Application Number: 2014-059      Application Date: 04/29/2014  
CBL: 254 A007001      Application Type: Level II Site Plan  
Applicant: OLD DOMINION FREIGHT LINE INC  
Project Name: Old Dominion Freight Line Addition  
Address: 185 RAND RD  
Project Description: 5,763 Sq Ft Addition enlarge pavement area and curb cuts off Rand Road  
Zoning: IM

**To:** FILE  
**From:** Barbara Barhydt  
**Subject:** Application ID: 2014-059  
**Date:** 7/15/2014

**Comments Submitted by: Marge Schmuckal/Zoning on 7/15/2014**

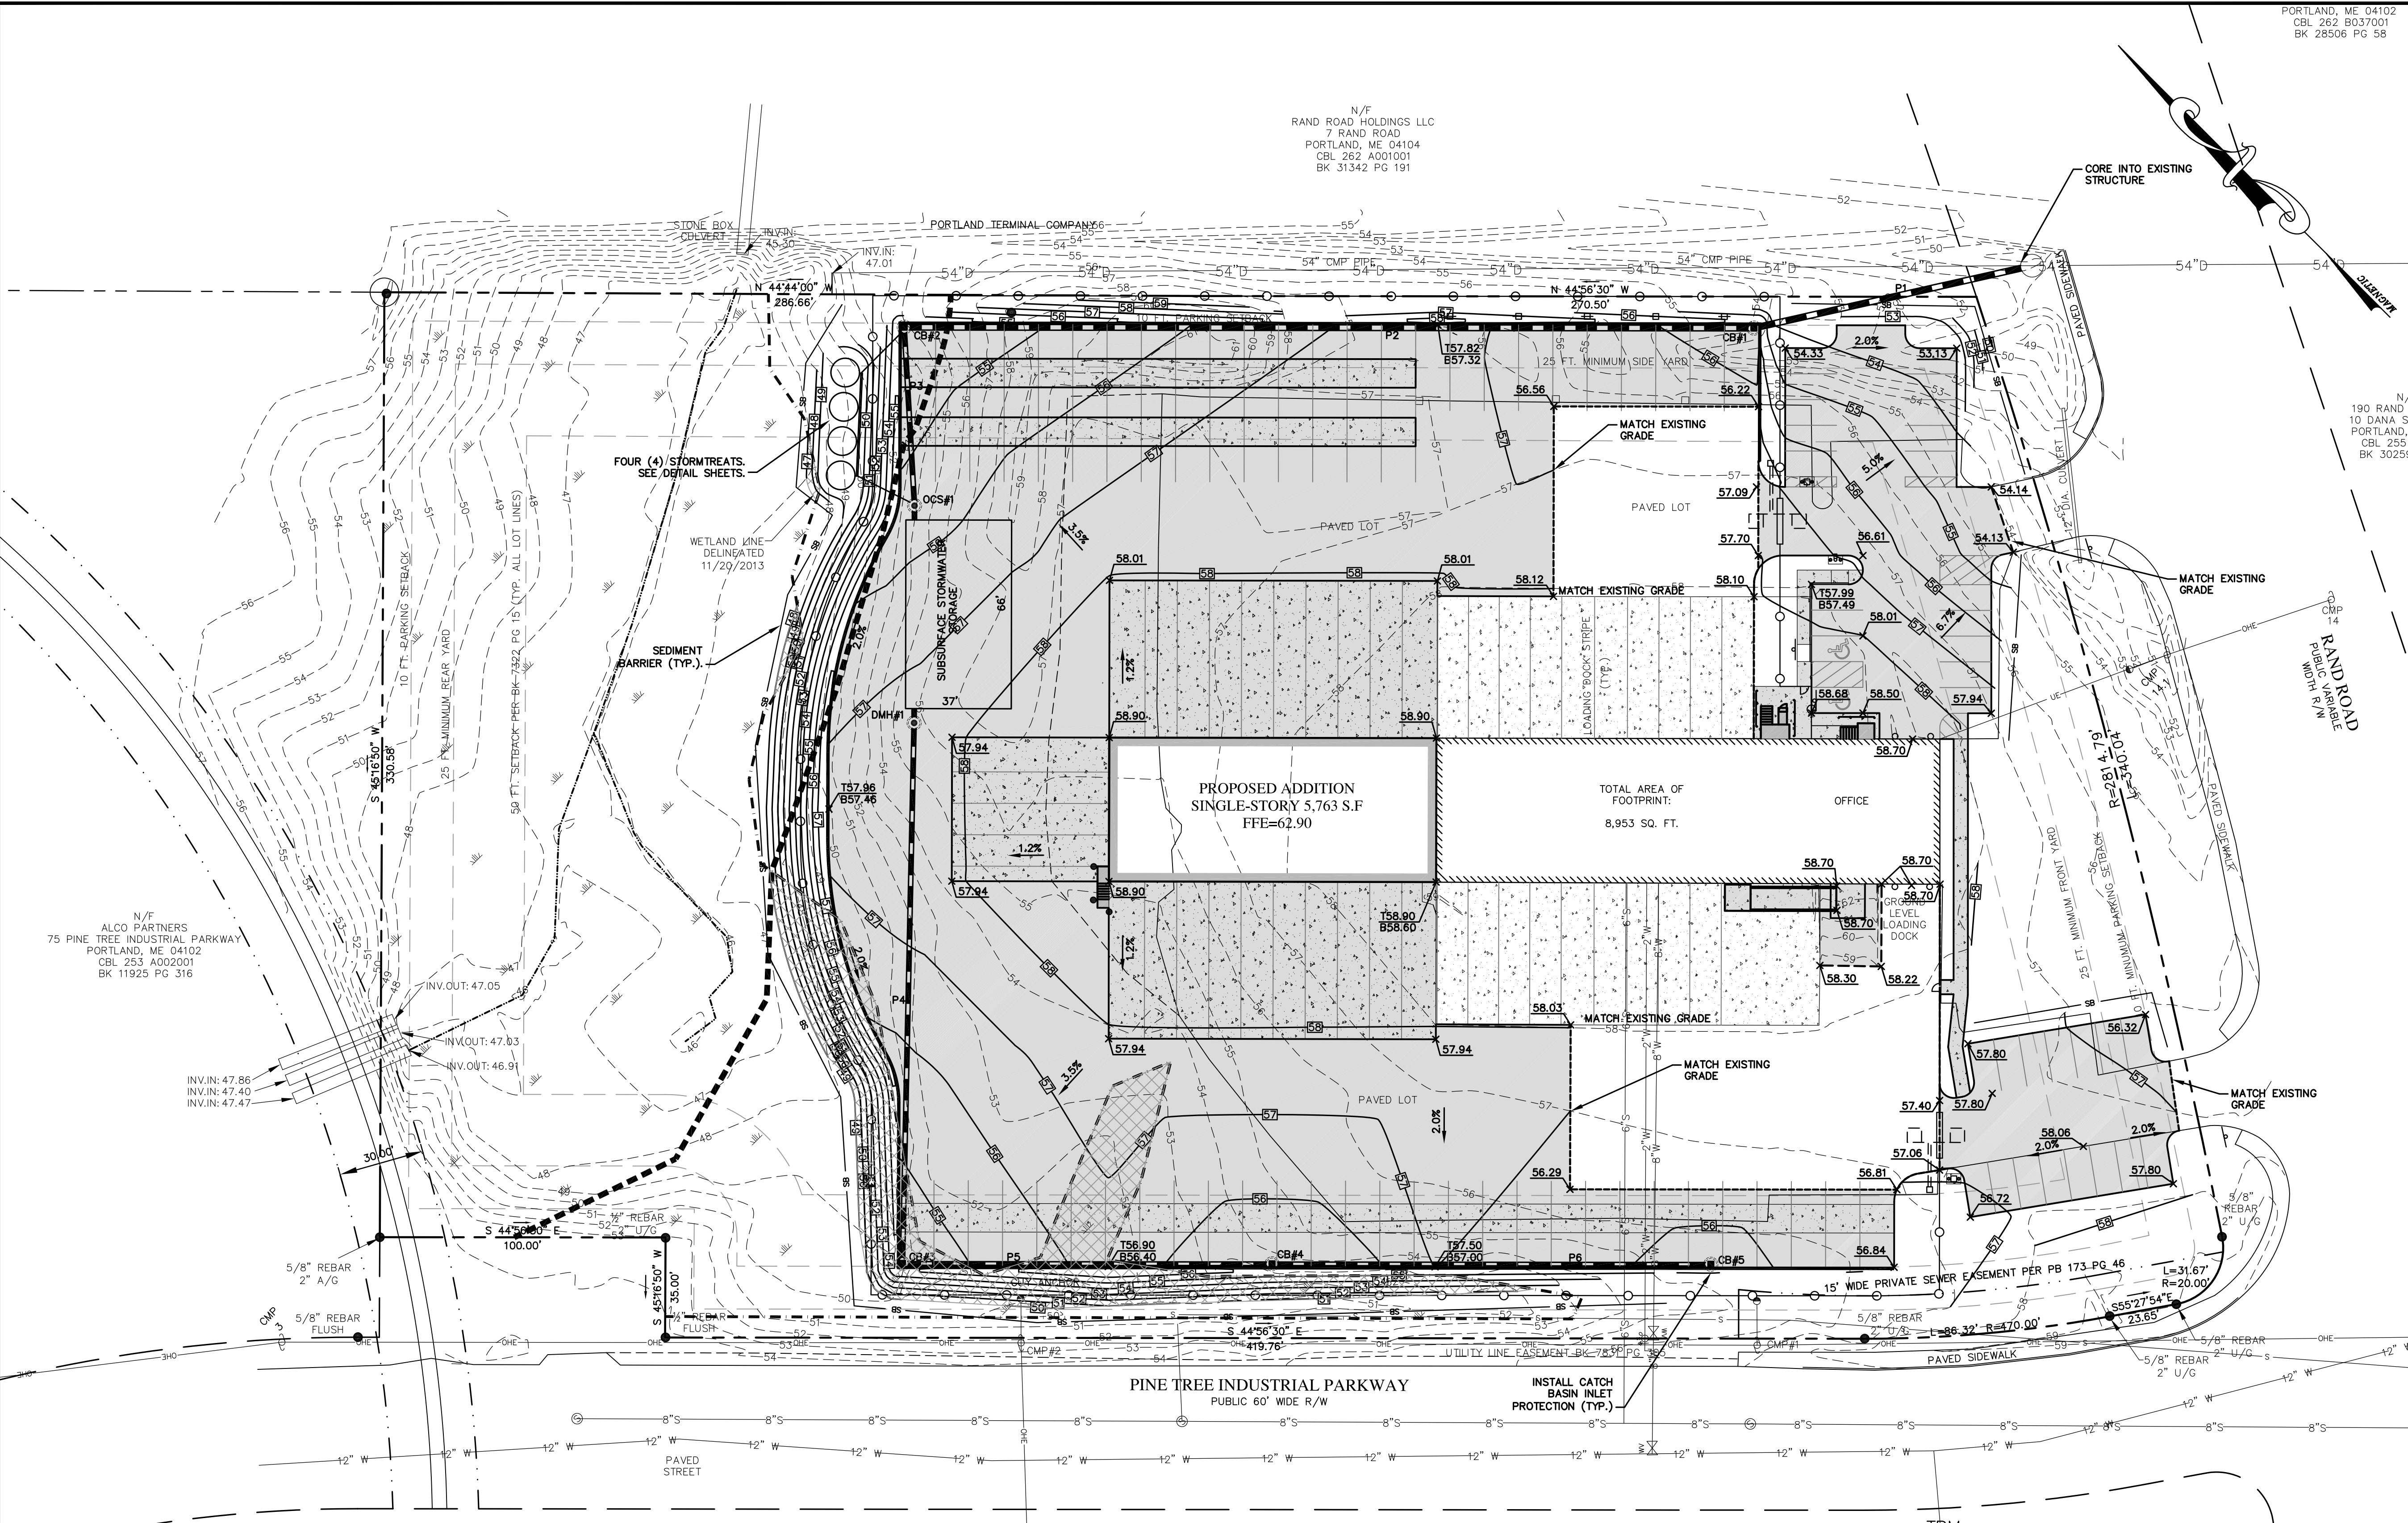
Plan C-4, the Grading, Frainage & Erosion Control Plan does show sediment barriers. 14-449(d) requires erosion and sedimentation control measures to apply to all aspects of the proposed project and shall be in operation during all stages of activity in accordance with the "Maine Erosion and Sediment Control Handbook for Construction: Best Management Practices". Any exposed ground area shall be temporarily or permanently stabilized within one (1) week from the time it was last actively work with the appropriate materials. Any vegetation removed or damaged by the construction activities shall be replaced in kind and repaired.
